GATWICK AIRPORT NORTHERN RUNWAY PROJECT

Planning Inspectorate's Reference: TR020005

Comments on The Applicant's Response To The ExA's Written Questions (ExQ1)

DEADLINE 4: 15 May 2024

Figure 13. Indicative Site Plan - Car park X Deck Parking

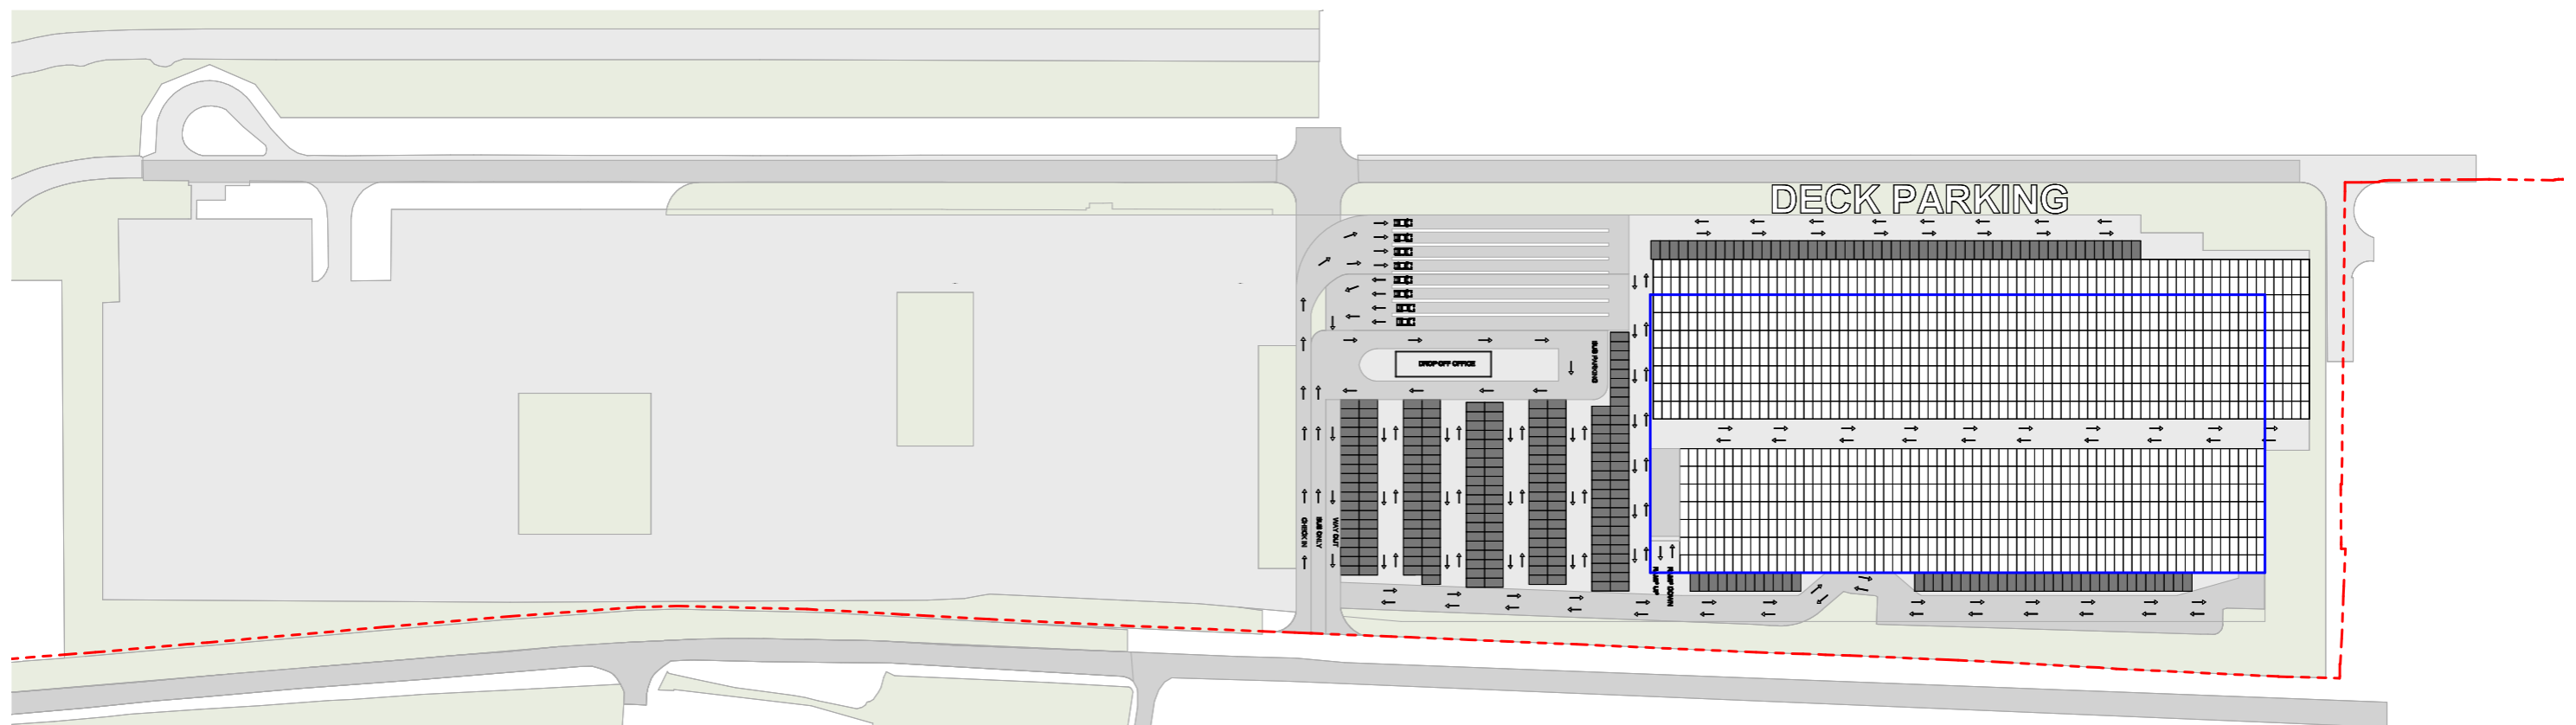
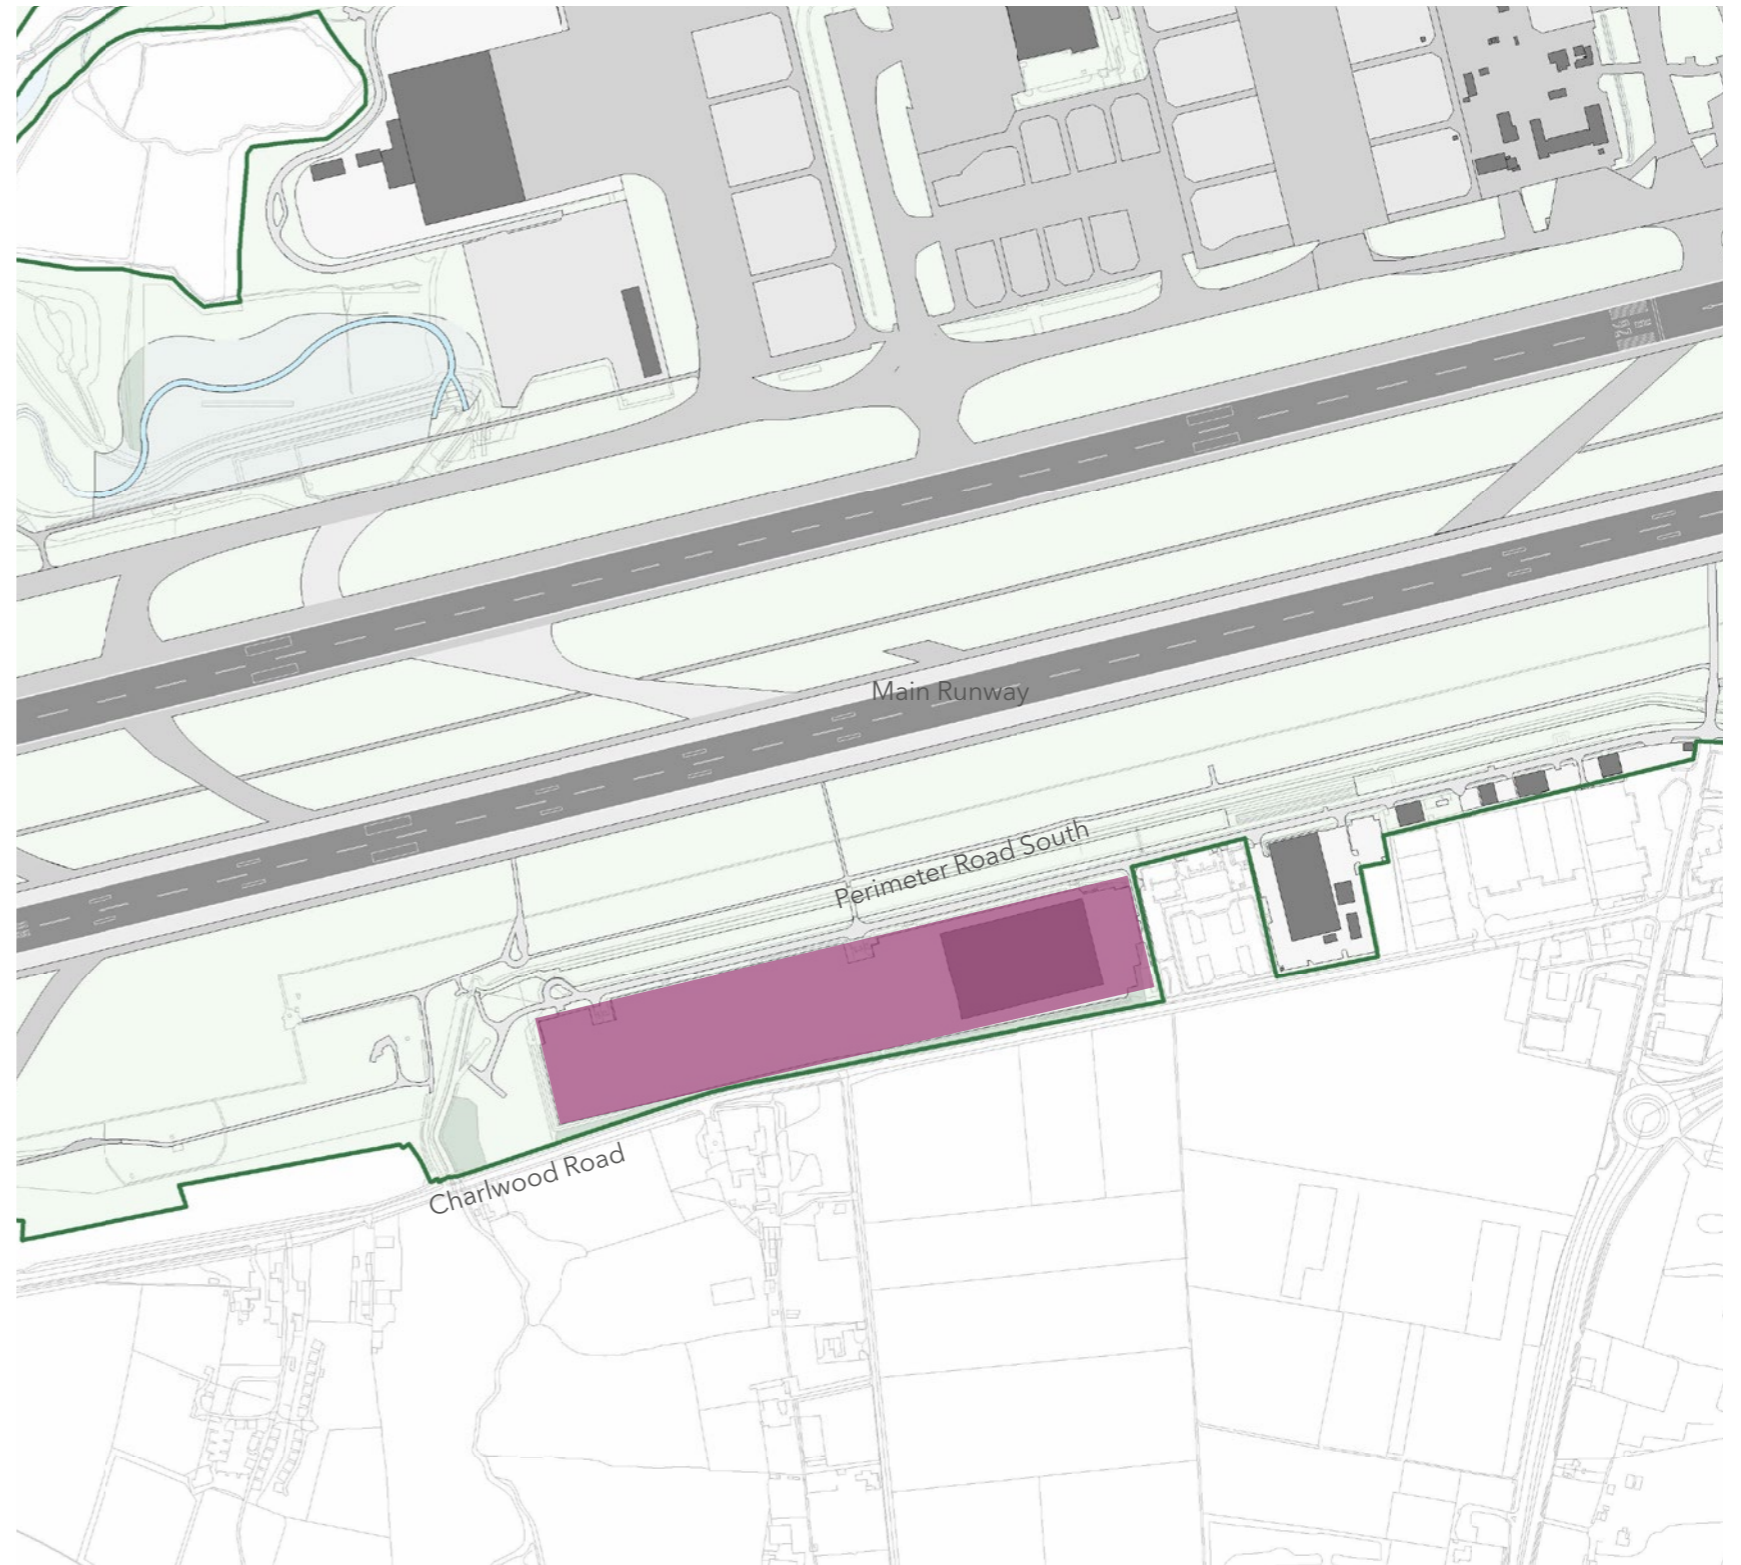
<p>LV.1.3</p>	<p>The Applicant</p>	<p>Landscaping</p> <p>Provide further details on landscaping proposals for the following areas:</p> <ul style="list-style-type: none"> a) North Terminal Decked Car Park; b) Car Park X; c) Car Park Y; and d) Purple parking (new). 	<p>While the Authorities note that no tracked changed documents have been provided for the Design and Access statement volumes 1 - 5, it appears no additional detail has been provided within these documents by the Applicant in response to this question. A more detailed response on the revised Appendix 1 – Design Principles document [REP3-056] is provided within a separate Joint West Sussex Authorities Deadline 4 submission.</p> <p>The response provided by the Applicant suggests that because they consider the car parks to be ‘excepted development’ they are not prepared to provide any further design detail. The Authorities do not accept this approach for the reasons set out in response Table 4 – Action Point 10 [REP2-081].</p>

<p>Such details to include existing survey plans, existing trees to be protected and proposed new/ reinforced landscape proposals.</p> <p>The DCO Application does not contain definitive layouts and designs for proposed car parks. The Design and Access Statement (DAS) [REP2-032, REP2-033, REP2-034, REP2-035, REP2-036] includes indicative plans and diagrams of car parks as follows;</p> <p>North Terminal Decked Car Park: DAS Volume 3 – Figures 22, 23 and 24</p> <p>Car Park X: DAS Volume 2 – Figures 12, 13 and 14</p> <p>Car Park Y: DAS Volume 3 – Figures 79, 80, 81 and 82</p> <p>Purple Parking: DAS Volume 2 – Figures 18, 19 and 20</p> <p>The accompanying Design Principles (Doc Ref. 7.3 v3) to the DAS include project-wide design principles for landscaping which sets out the design of native tree, shrub and hedgerow planting that would be appropriate for car parks within the Project. In particular, Landscaping Design Principle L4 directs that any vegetation will be retained and incorporated into the design where feasible to minimise impacts on character and visual resources. Alongside the project-wide design principles, site-specific design principles are included for individual works. This includes site-specific principles for Car Park X (DBF9), Car Park Y (DBF20, DDP10 and DLP14) and for surface, multi-storey and decked car parking (DBF7 to DBF11).</p> <p>The detailed design must be prepared in accordance with the Design Principles (Doc Ref. 7.3 v3), as secured under Requirement 4 of the dDCO (Doc Ref. 2.1 v6). The Applicant considers that the provision of these car</p>	<p>The level of detail is inadequate, the Authorities have seen no tree protection or landscaping plans with sufficient detail matched to corresponding design information to be certain that trees and landscaping within and surrounding the car parks would be safeguarded.</p>

<p> parks would constitute “excepted development” as set out in The Applicant’s Response to ISH2 Actions [REP1-063] and therefore, in line with DCO Requirement 4, the Applicant would consult CBC on the detailed design of these developments. </p> <p> The assessment within Section 8.9 of ES Chapter 8: Landscape, Townscape and Visual Resources [APP-033] is based on the maximum design scenarios set out in Table 8.7.1. The figures in the DAS provide an indication of car park development of this scale and nature within these locations. Landscape proposals have not been designed at this stage, however a general principle of perimeter planting in the form of linear belts of native trees, shrubs and hedgerows to screen and soften development has been included in ES Appendix 8.8.1 Outline Landscape Ecology Management Plan [REP2-021, REP2-023, REP2-025, REP2-027], more specifically Section 3: Landscape and Ecology Zone Objectives (Zones 1 and 5) and the assessment and mitigation of effects is included in Section 9 of ES Chapter 8: Landscape, Townscape and Visual Resources [APP-033]. </p> <p> ES Appendix 8.10.1: Tree Survey Report and Arboricultural Impact Assessment [REP1-026, REP1-027, REP1-028, REP1-029, REP1-030] includes tree survey plans and schedules covering these specific car parks, alongside removal plans based on the preliminary design work. Measures to protect retained trees and vegetation are detailed within the Outline Arboricultural and Vegetation Method Statement, forming Annex 6 of the CoCP (Doc Ref. 5.3), and will be confirmed based on the final detailed design through Detailed Arboricultural and Vegetation Method Statements for approval by CBC (in consultation with other relevant authorities) prior to any tree or vegetation removal. </p>
